From:
Sent: 17 September 2024 17:35
To: DC Admin
Cc:
Subject: Comments on application 2024/92167 Clayton Fields Development

Comments on application 2024/92167 Clayton Fields Development

Deveron Grove
Proposed Site Layout

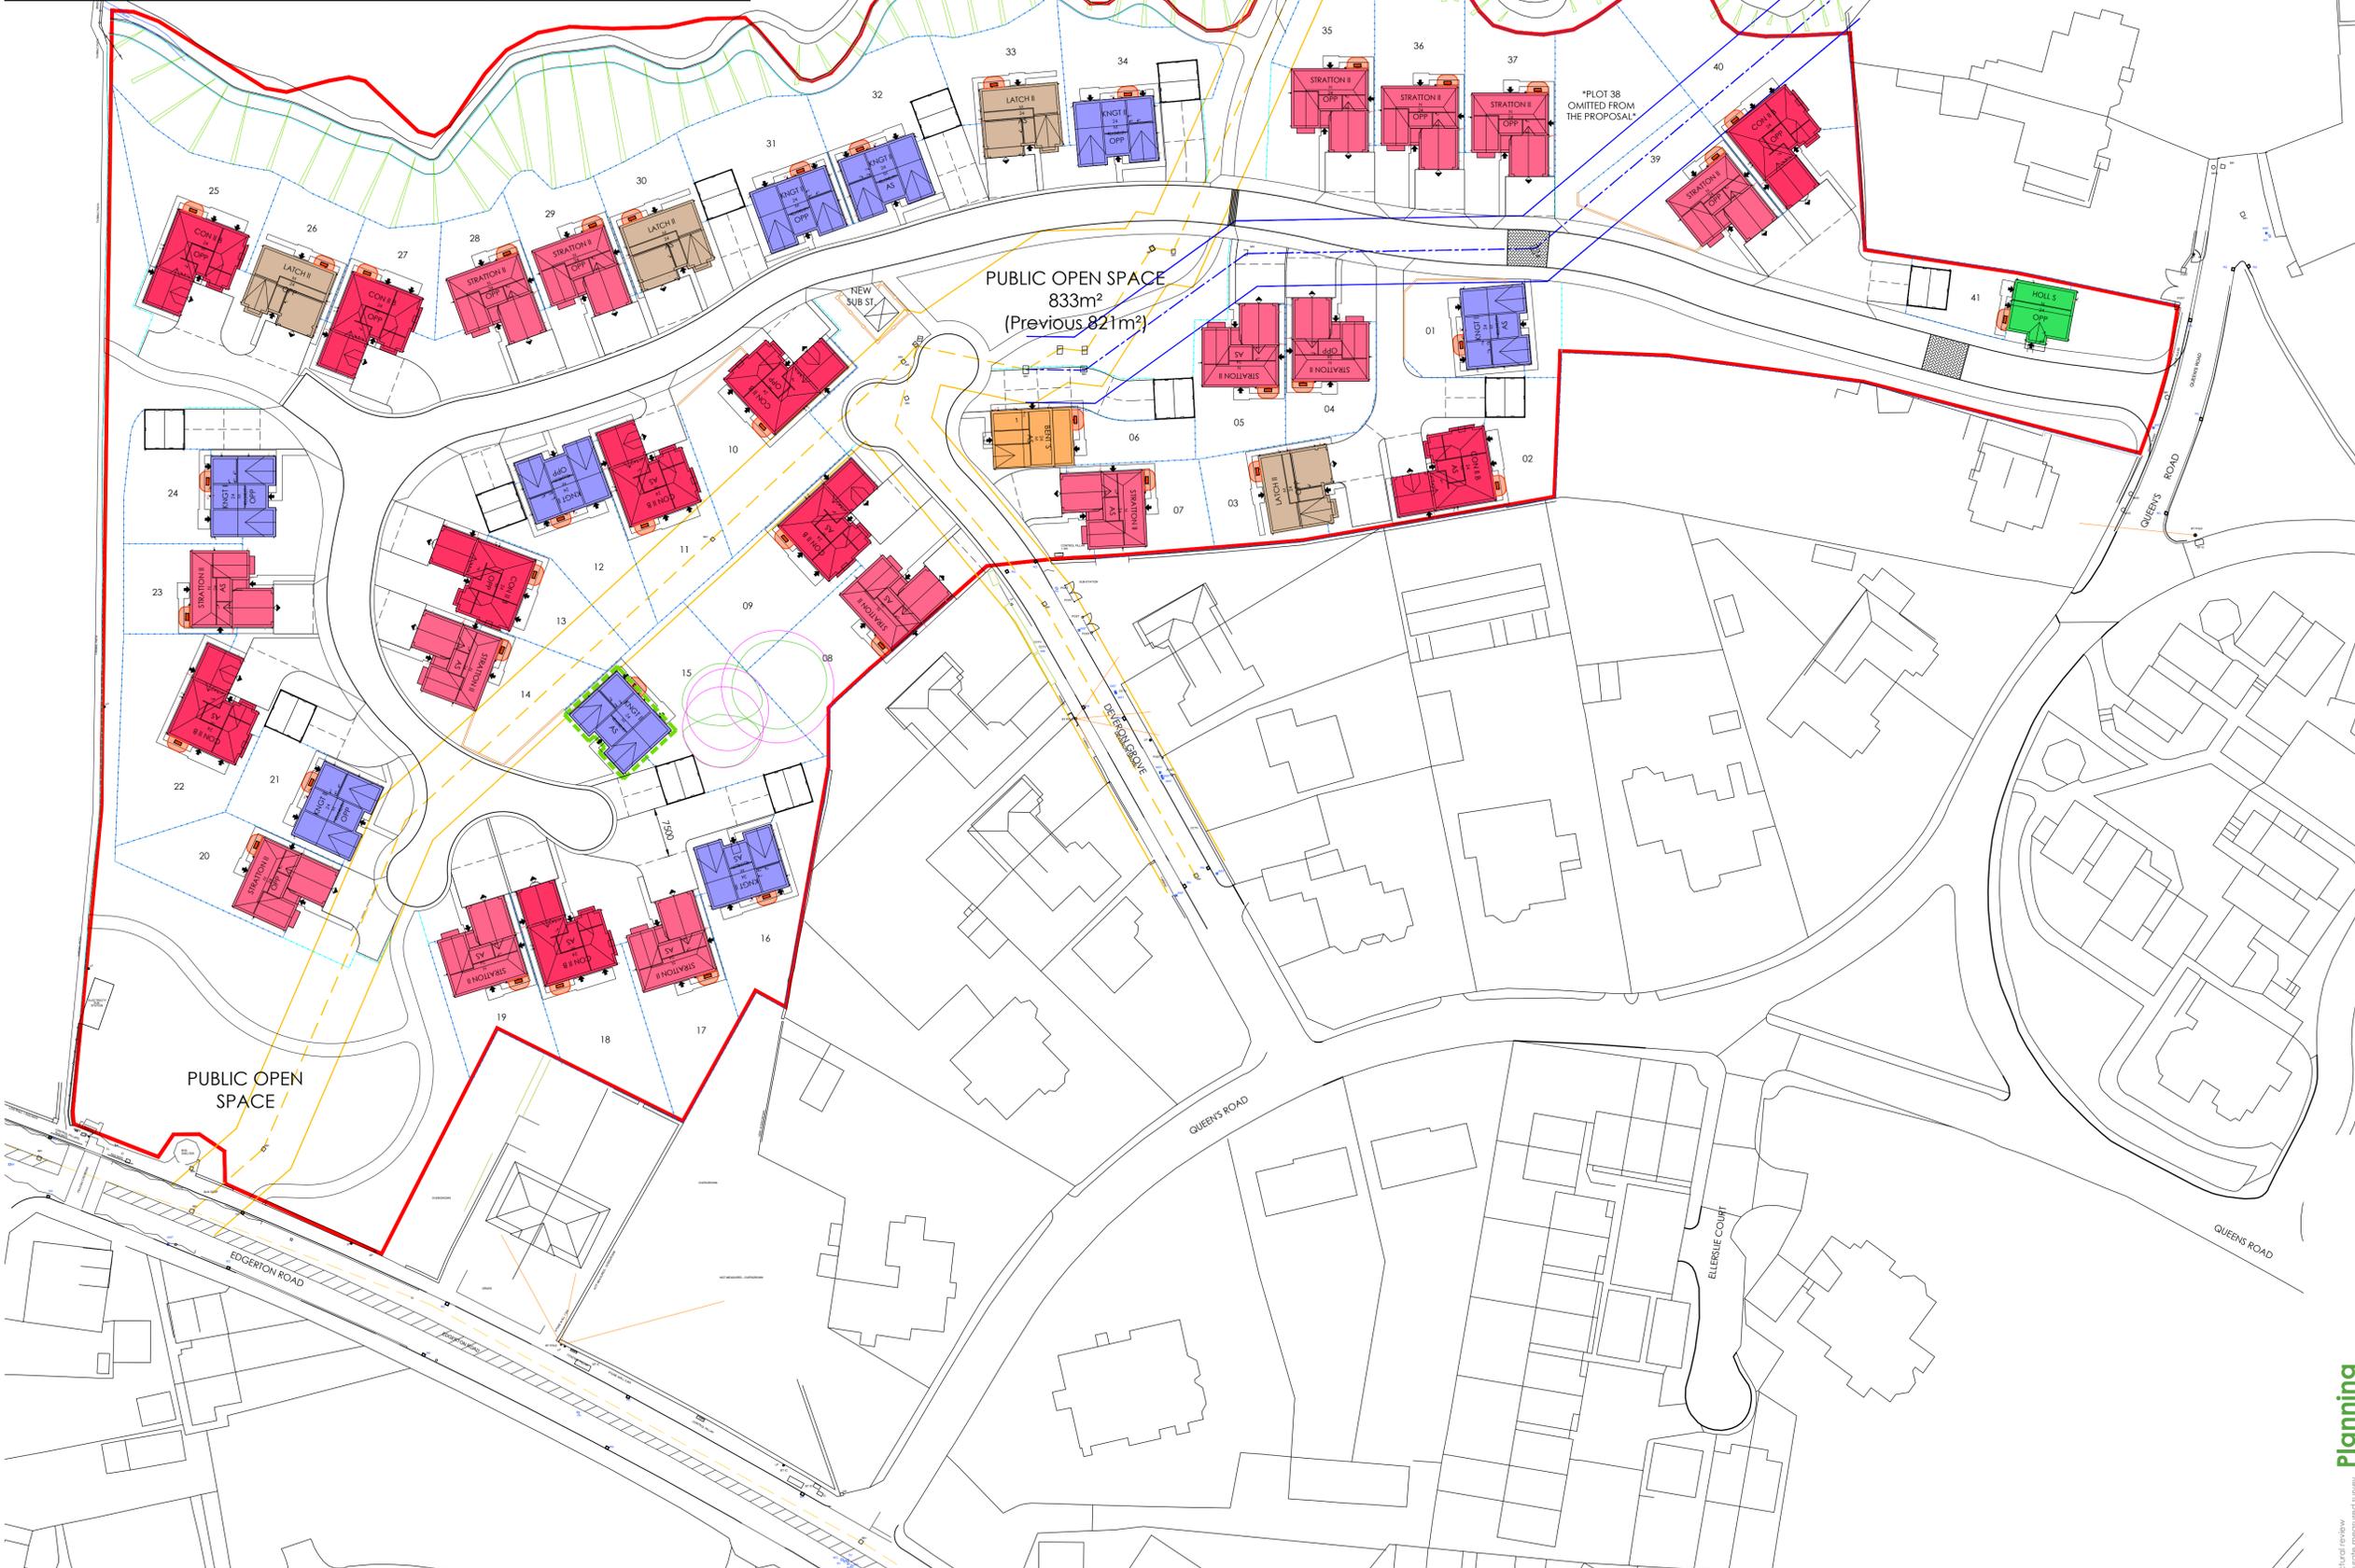
1. Technical and legal issues with plans: There are some technical matters that are wrong with this application. The land concerned goes over Clayton Dyke but in actual fact the land owned by the developers does NOT go over Clayton Dyke.

2. Need to avoid town cramming, loss of light and overshadowing: The dwellings come very close to the property line between 4 Queens Road garden and Clayton Fields. In effect, these properties will be overlooking rooms in 3 and 4 Queens road with the ensuing loss of privacy. They will also block light and movement of wind They will render the gardens permanently in the shade.

5. Height variation and loss of privacy: The height variations between the houses on Deveron Grove, Queens Road and the proposed buildings on Clayton Fields mean that the proposed houses will be looking into kitchens, bedrooms, back gardens of the houses on Deveron Grove and Queens Road with ensuing great loss of privacy.

8. Highway safety, parking and access: It looks like all the traffic from these houses will be channeled into Queens Road, which already faces many issues as a result of being used as a 'rat run' between Halifax and Blacker Roads. This can only make things much worse, making the road more dangerous for existing residents.
